**Cheshire West and Chester Council's Representation Made at  
Deadline 8**

**Submitted at Deadline 8 – 12 September 2023**

- 1.1. Cheshire West and Chester Council (**the Council**) is one of the host authorities for the for the Liverpool Bay CCS Limited's (**the Applicant**) HyNet Carbon Dioxide Pipeline DCO project (**the Project**)
- 1.2. This document is the Council's Written Representations, submitted at Deadline 8 of the Examination into the DCO.

PROJECT TITLE  
**HyNet Carbon Dioxide Pipeline DCO**

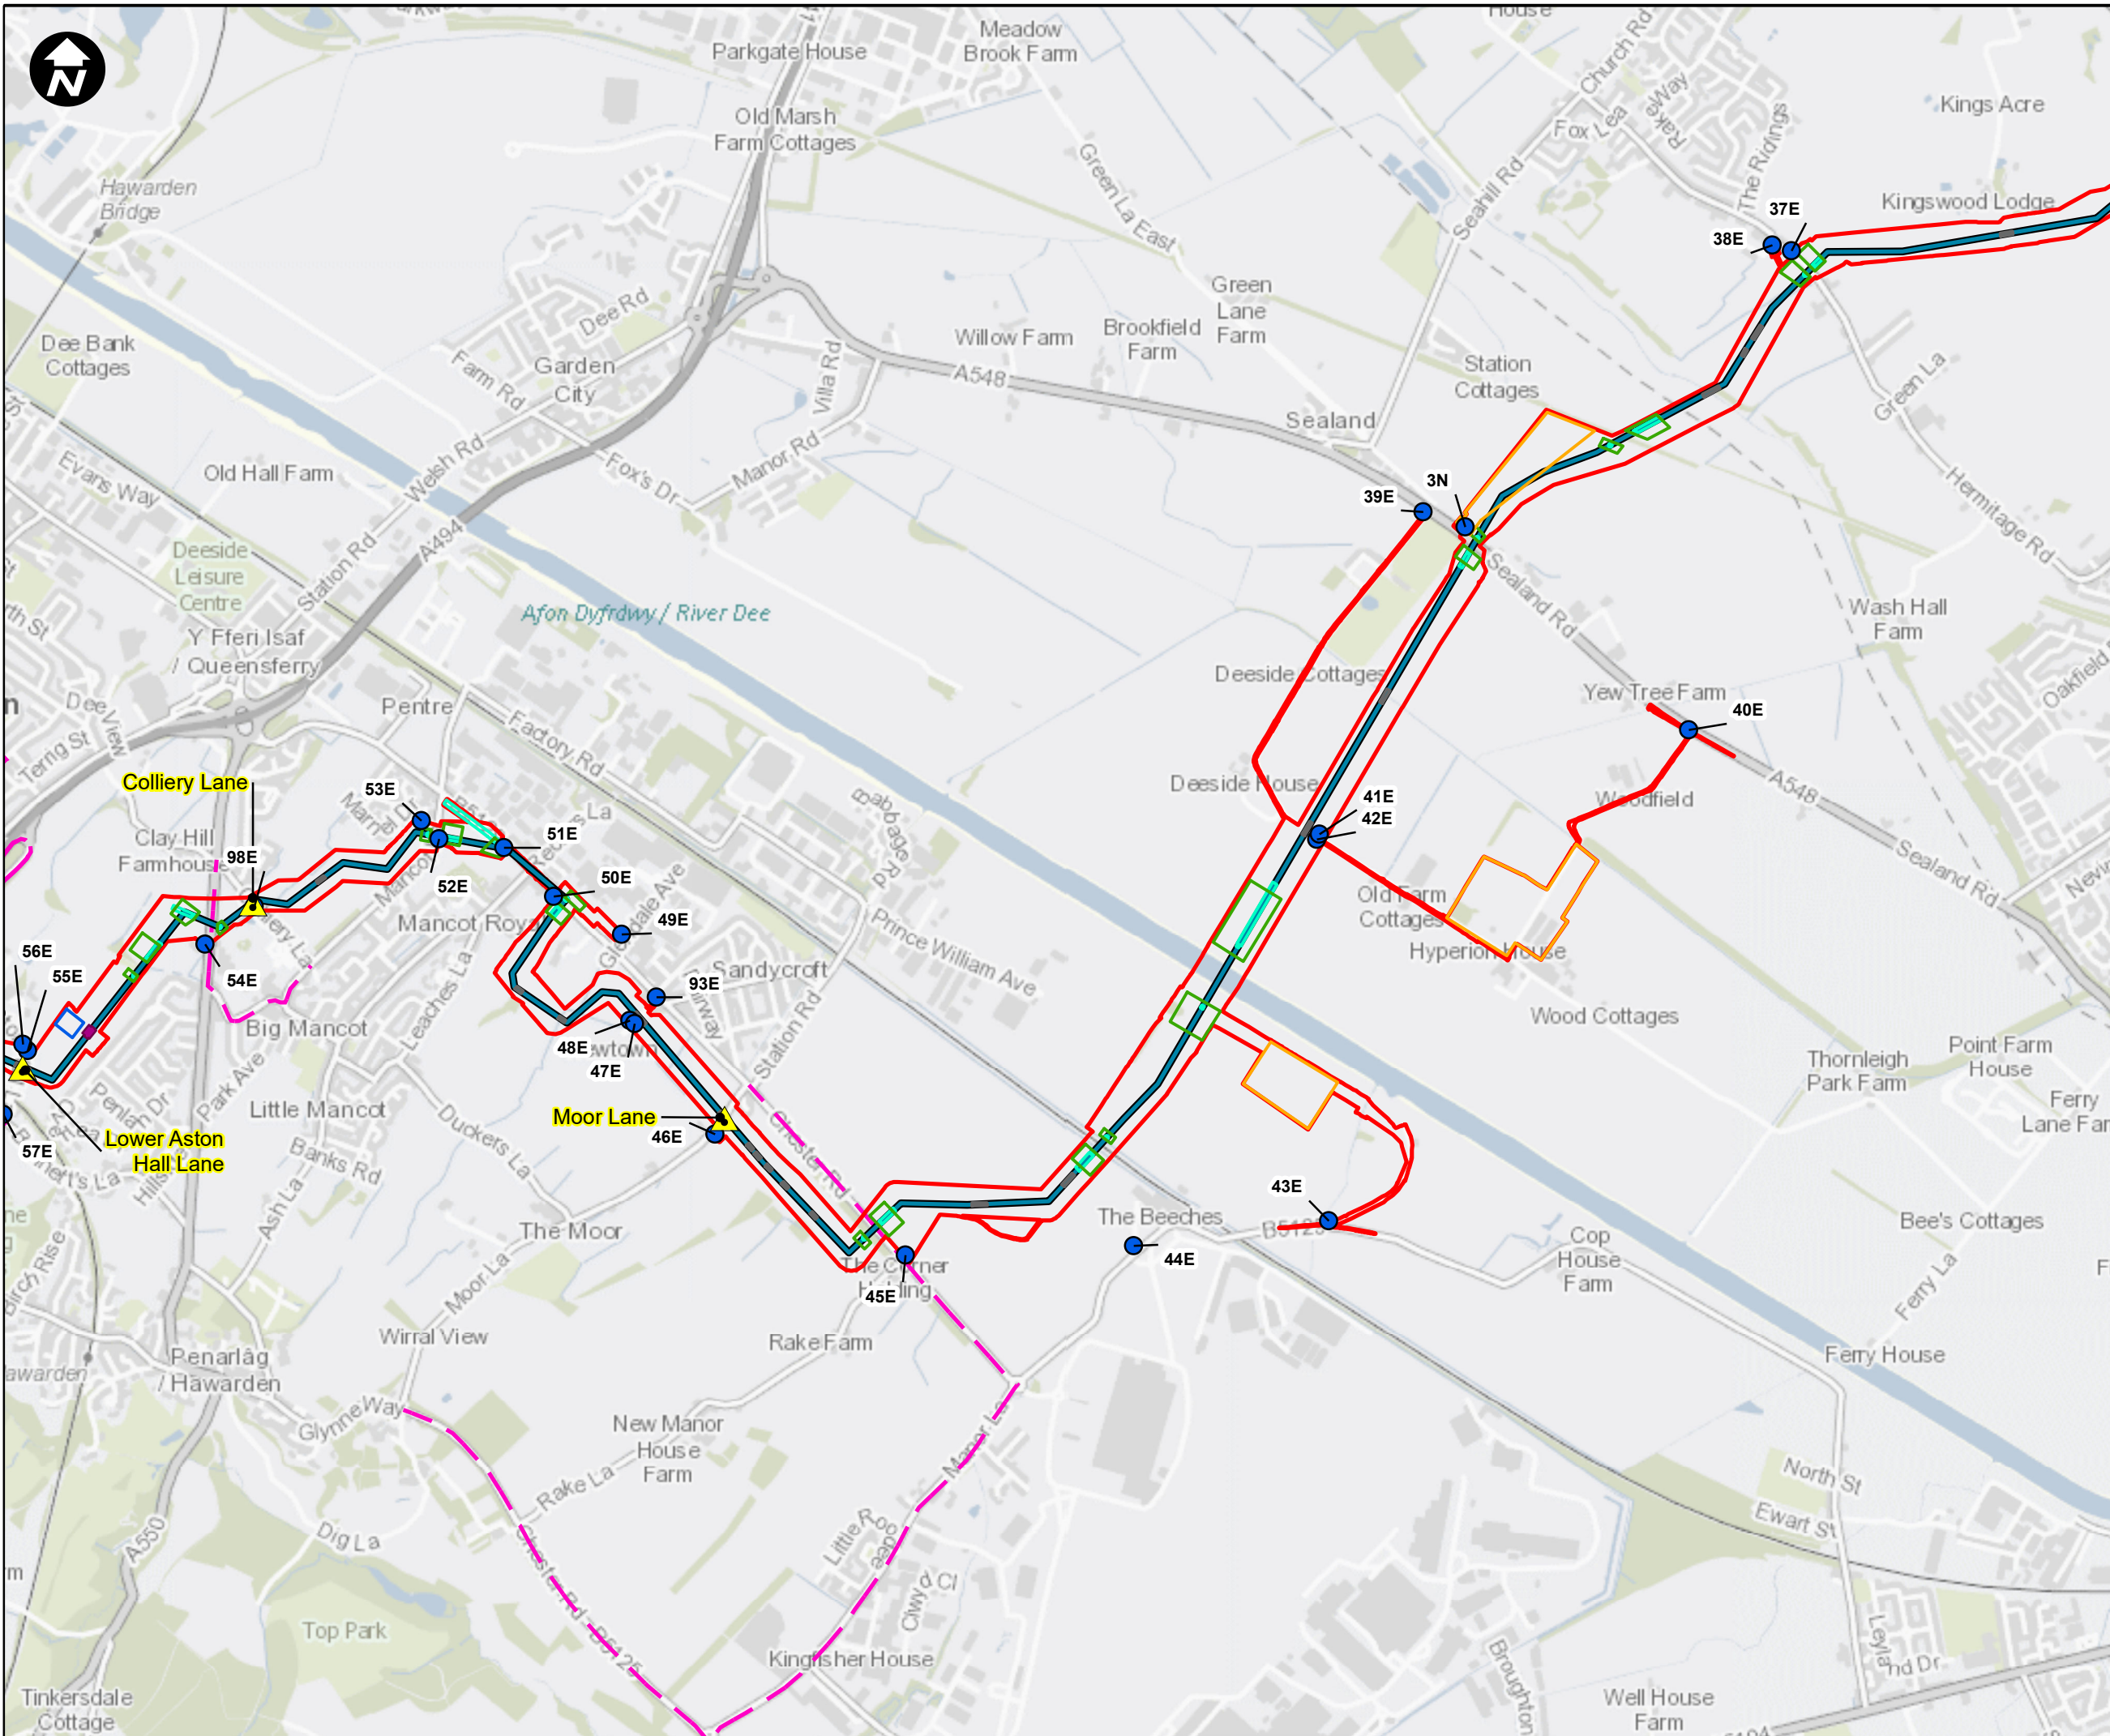
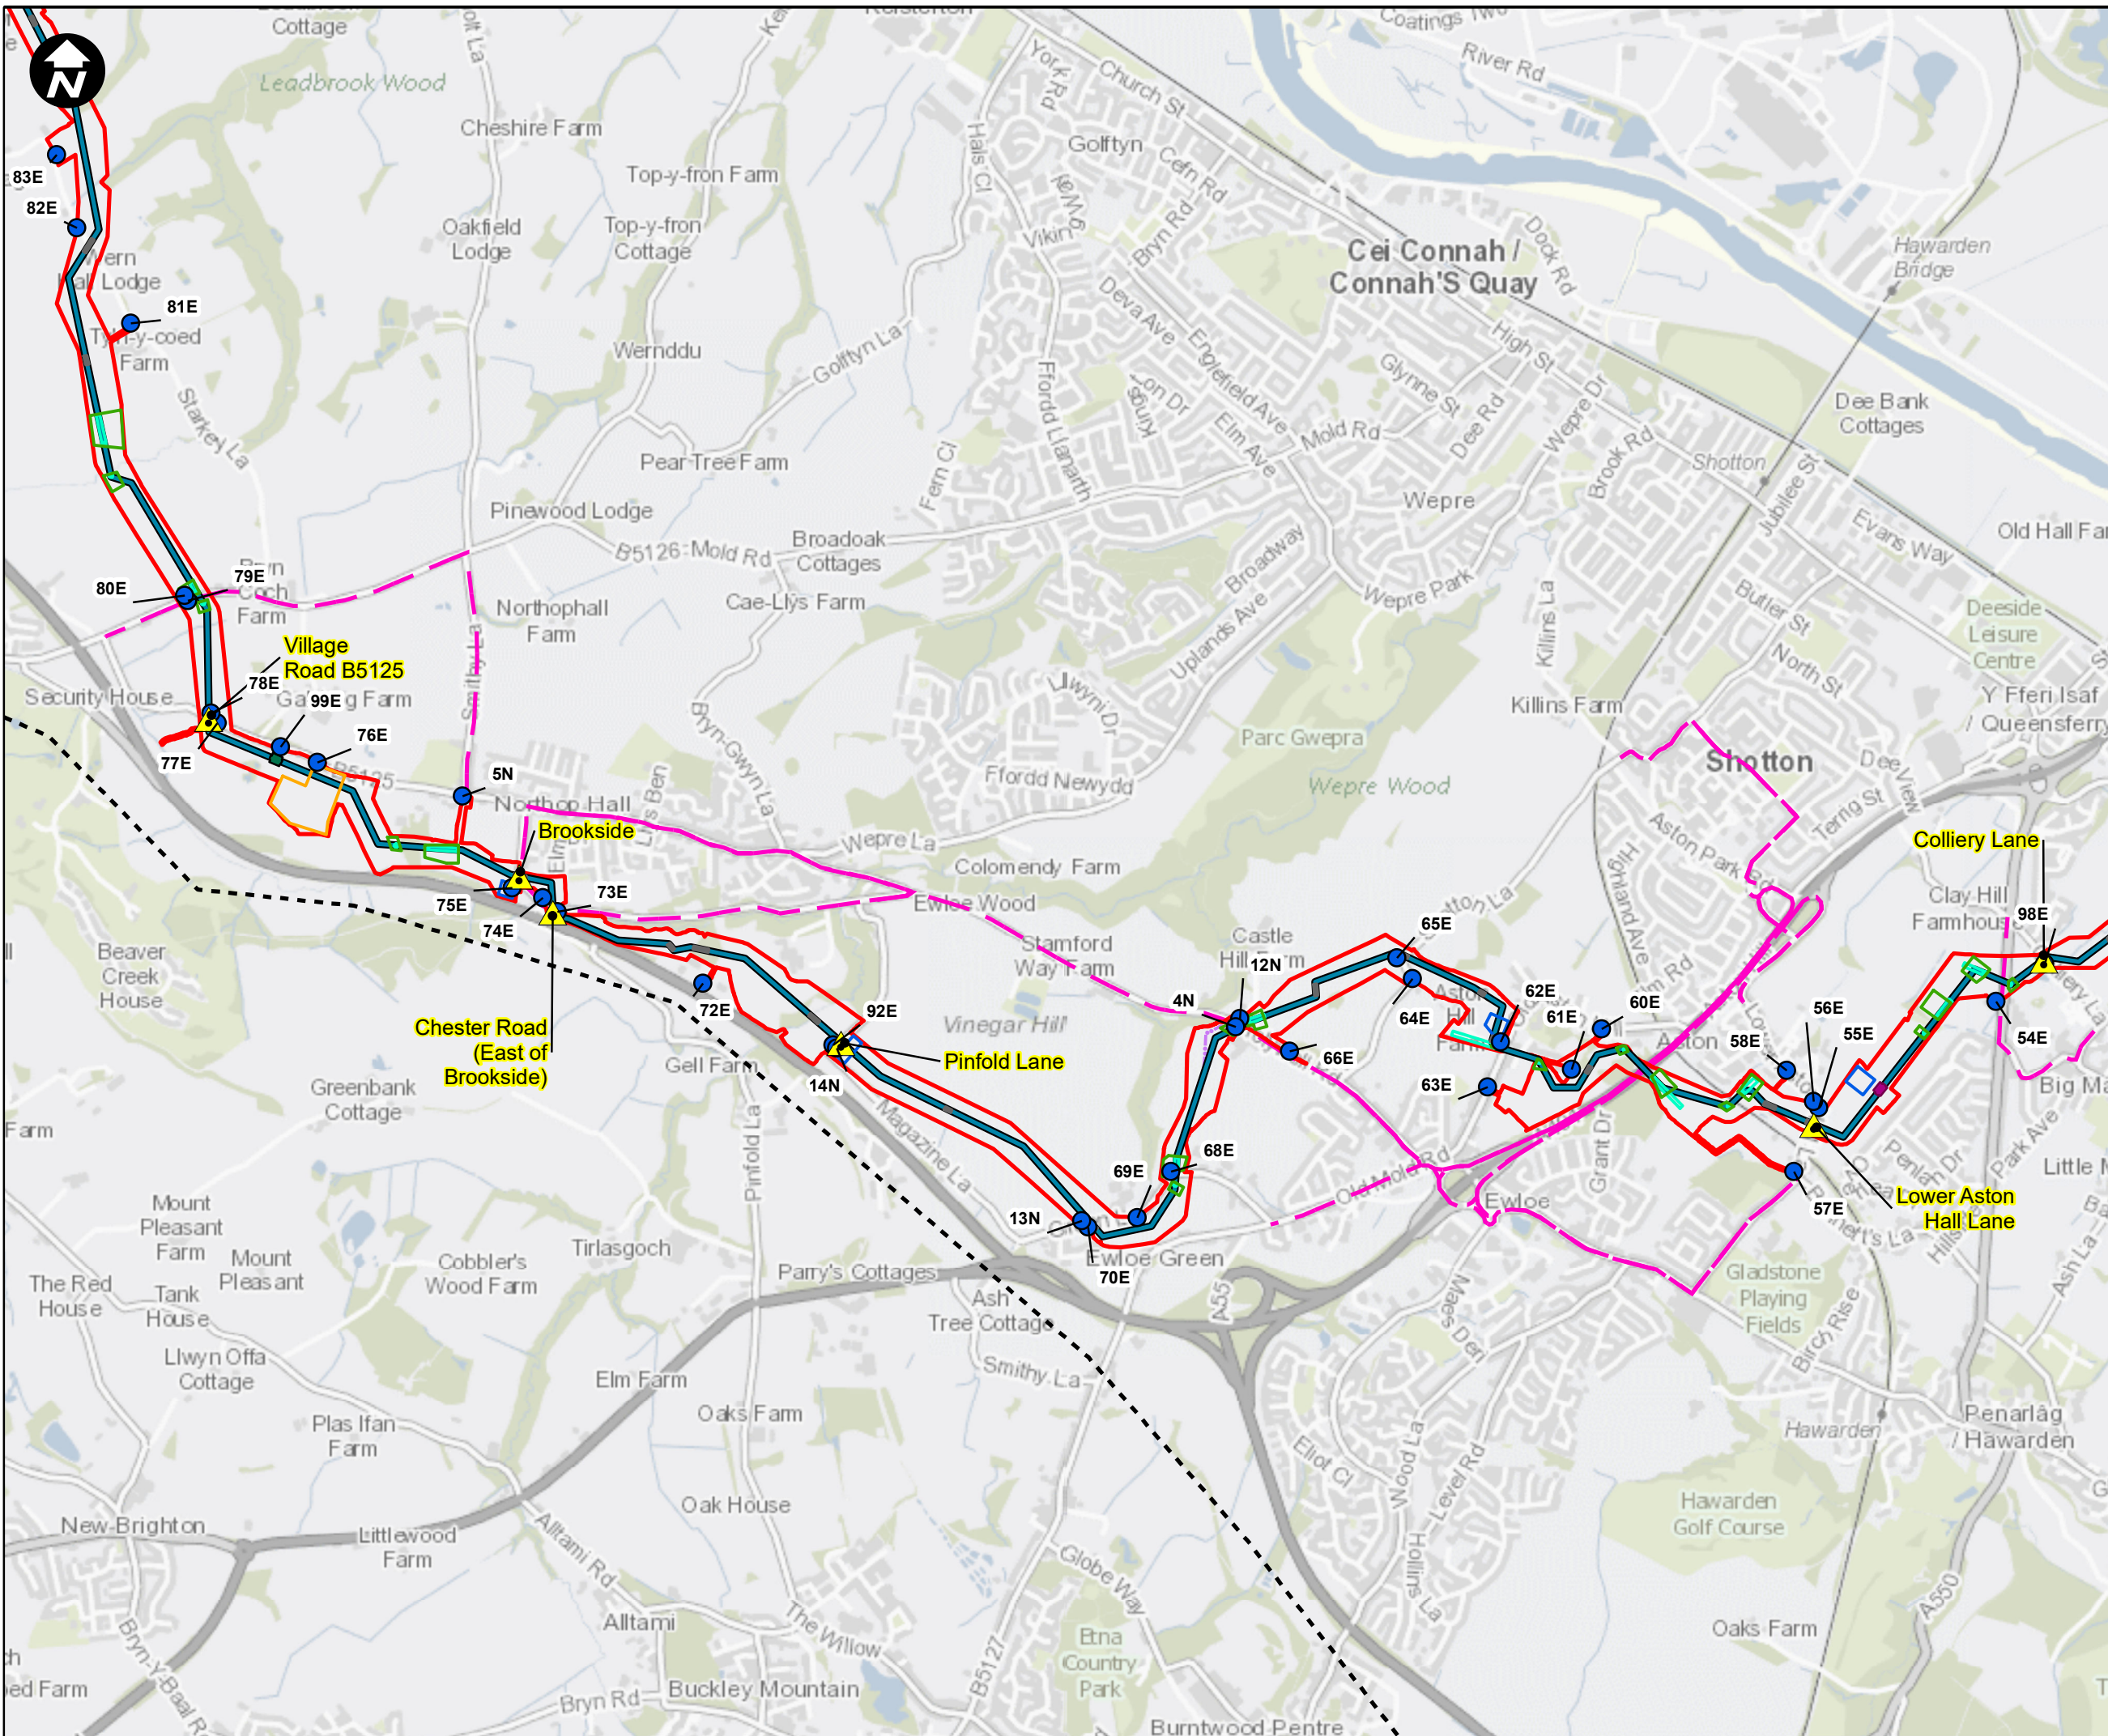
Paragraph	Text	The Councils Response
5.5.3	These are presented in <b>Figure 17-7 - Road Diversions (Volume IV of the ES) [CR1-095]</b> .	The Council notes that the diversion routes included have not been indexed and is not clear which route is used for which closure.

7.3.4	The following mitigation is proposed:  <ul style="list-style-type: none"> <li>• During the Construction Stage, advanced warning signage will be implemented to slow vehicle speeds on approach to construction accesses and warn other road users of site traffic</li> <li>• Provision of Manual for Streets (MfS) compliant visibility splays with associated verge trimming and clearance; and</li> <li>• It is recommended that 'Slow' road markings on the eastbound approach to the permanent access location to reduce 85th percentile speeds are implemented for the operation and maintenance stage of the DCO Proposed Development.</li> </ul>	The Council notes that the CC CTR 2 and BVS CTR 1 routes are incorrect and they do not account for one-way systems, hence the Council requiring detailed diversion route indexed per closure/works location.
